RE: Juan Tabo Hills Estates Preliminary Plat, Project # 1005278

The purpose of this letter is to explain how the comments as contained in the DRB Official Notice of Decision (May 21, 2015) have been addressed. The following items have been revised and are being re-submitted for review and approval.

NEW SANITARY SEWER EASEMENTS

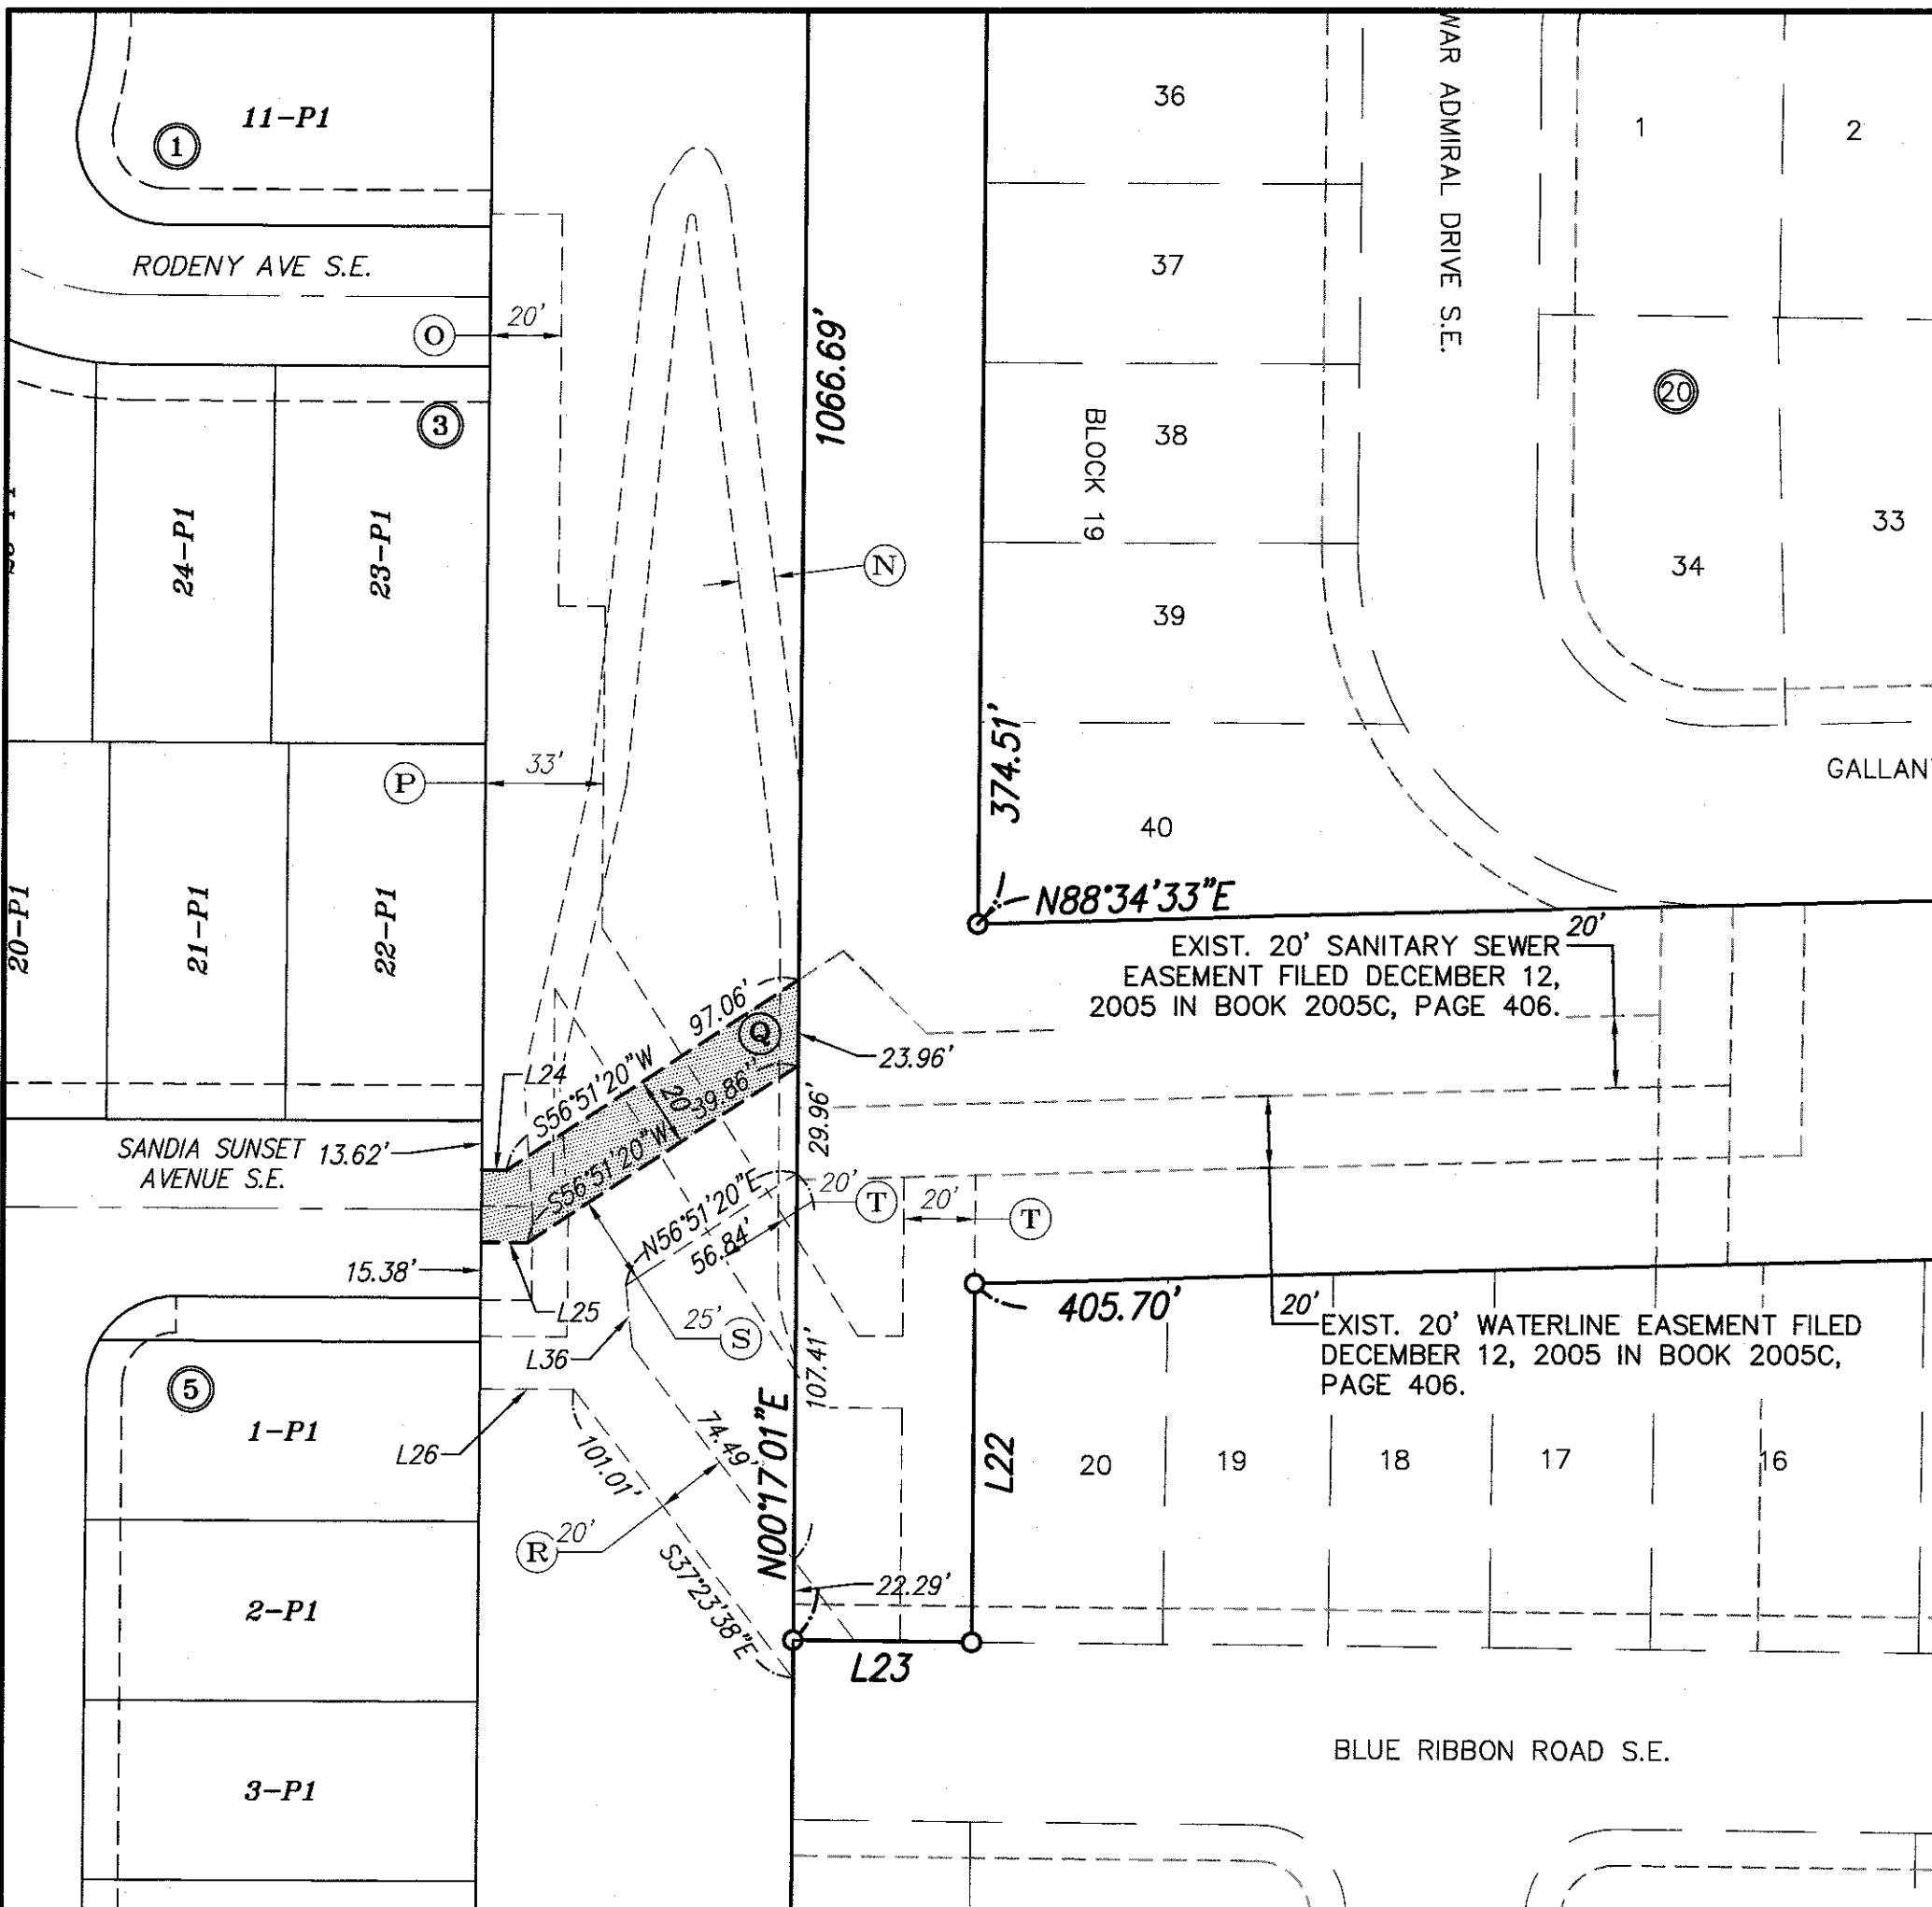
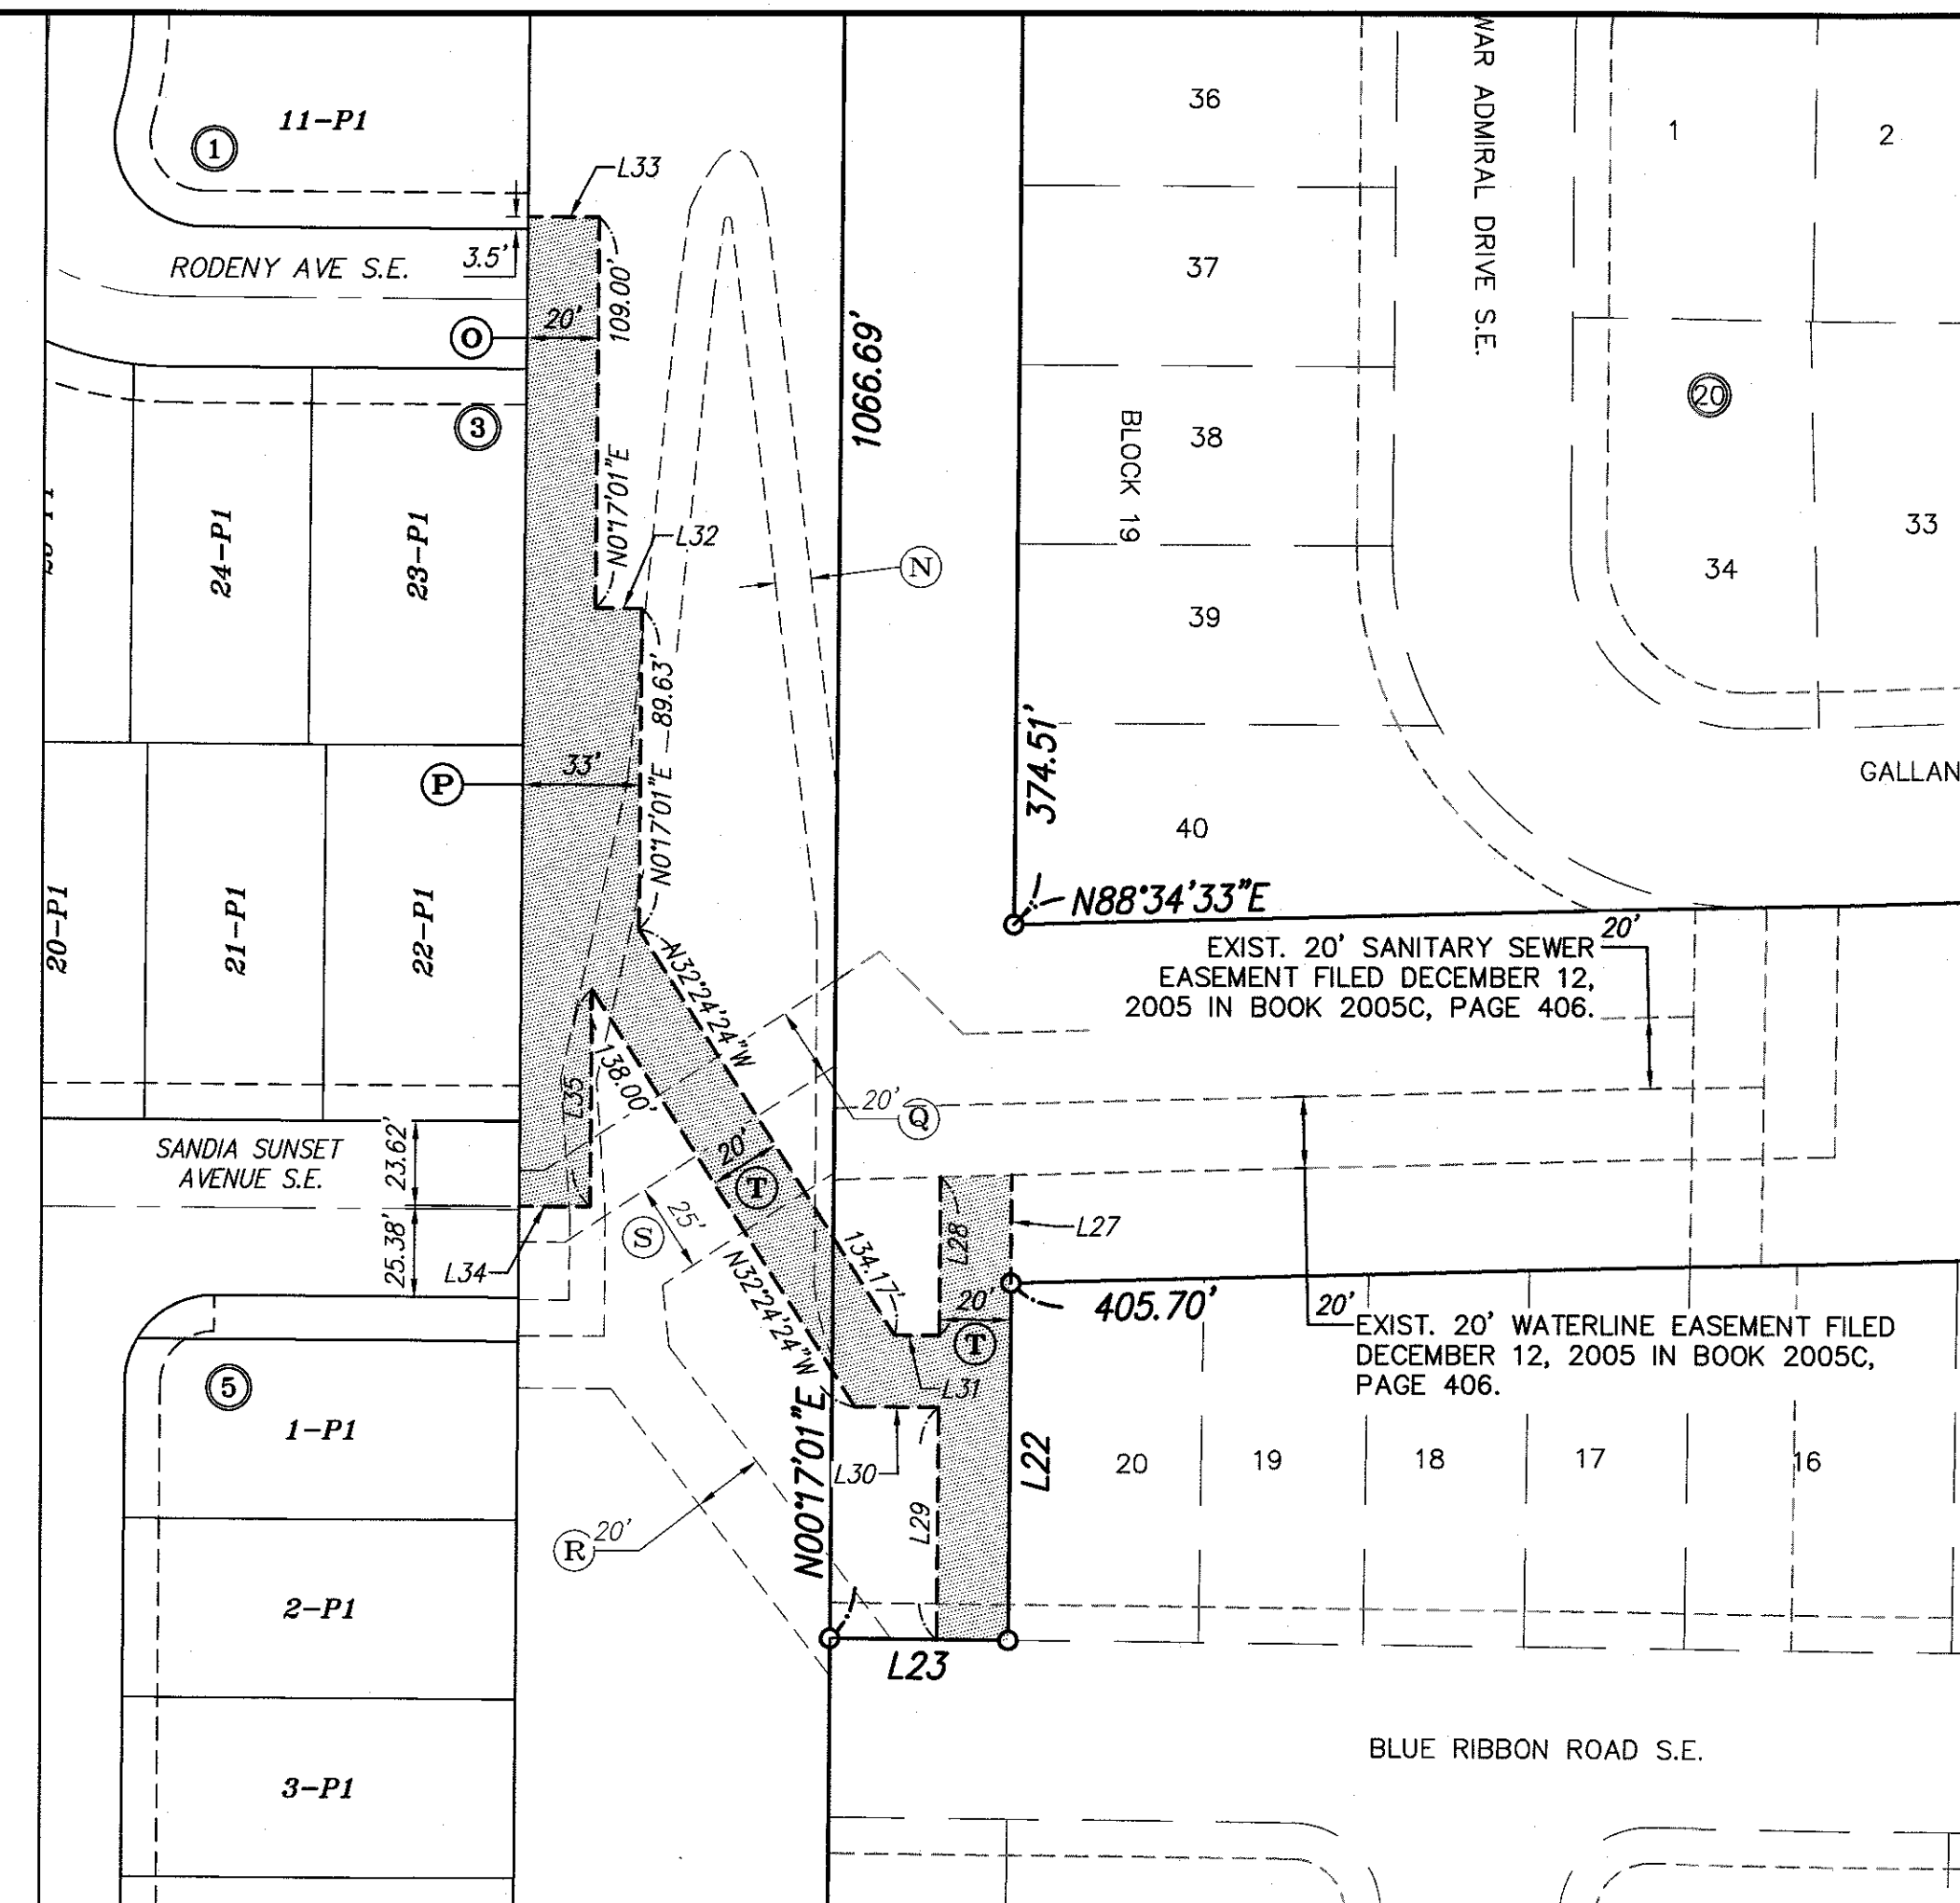
ABCWUA comments (1.) A development agreement has been submitted to ABCWUA for Board approval. It should be introduced to the Board at the October 21 meeting and then hopefully approved at the following meeting on November 18. (2.) Mark Goodwin is not willing to provide an acknowledgement letter. (3.) Site Plan comments are not applicable since the Conceptual Utility sheet has been removed from the Site Plan. However the Conceptual Utility Plan has been updated and provided as an aid to review of the Preliminary Plat and the Infrastructure List. (4.) The Infrastructure List has been revised by (4.i) changing the 8" water lines to 10" in Pocono Rd, Silver Dollar St, Manzano Vista Ave, Rock Squirrel and Sandia Sunset, (4.ii) 8" water line connection added between the existing line in Blue Ribbon Rd and the existing line in Tract 1-A-1-B which connects to Gallant Fox Rd., (4.iii) the 6" waterline in the stub on the south end of Hubbard remained 6" on the infrastructure list and was changed to 6" on the Conceptual Utility Plan, (4.iv) the north end of the Canyon Wren water line was changed to 8", (4.v) the 6" water lines in stub streets were changed to 4" water lines, (4.vi) the White Dove St. water line was changed from 6" to 8", (4.vii) the removal of the existing 21" SAS was added, (4.viii) the removal of the existing 8" SAS in Tract 1-A-1-B was added, and two Pressure Reducing Stations were added to the Infrastructure List. (5.) The Preliminary Plat was revised by adding the Vacation of a portion of Tract D to Sheet 1, and by separating the storm easements from the sanitary and waterline easements.

added to the Grading Plan. Separate permits will be obtained from the Corps of Engineers and AMAFCA that will address fencing along the arroyo. (6.) Ten foot wide AC Trails have been added to tracts H and J and are located in the best place available to insure privacy of the residents. AMAFCA has no objection to the approval of the Preliminary Plat and will be reviewing more detailed plans after Preliminary Plat Approval keeping in mind federal water quality standards and regulations.

streets are wide enough to accommodate on street parking. Finally the 4' sidewalks were changed to 10' wide AC trails in response to DMD comments and the 2040 Long Range Bikeway System Map.
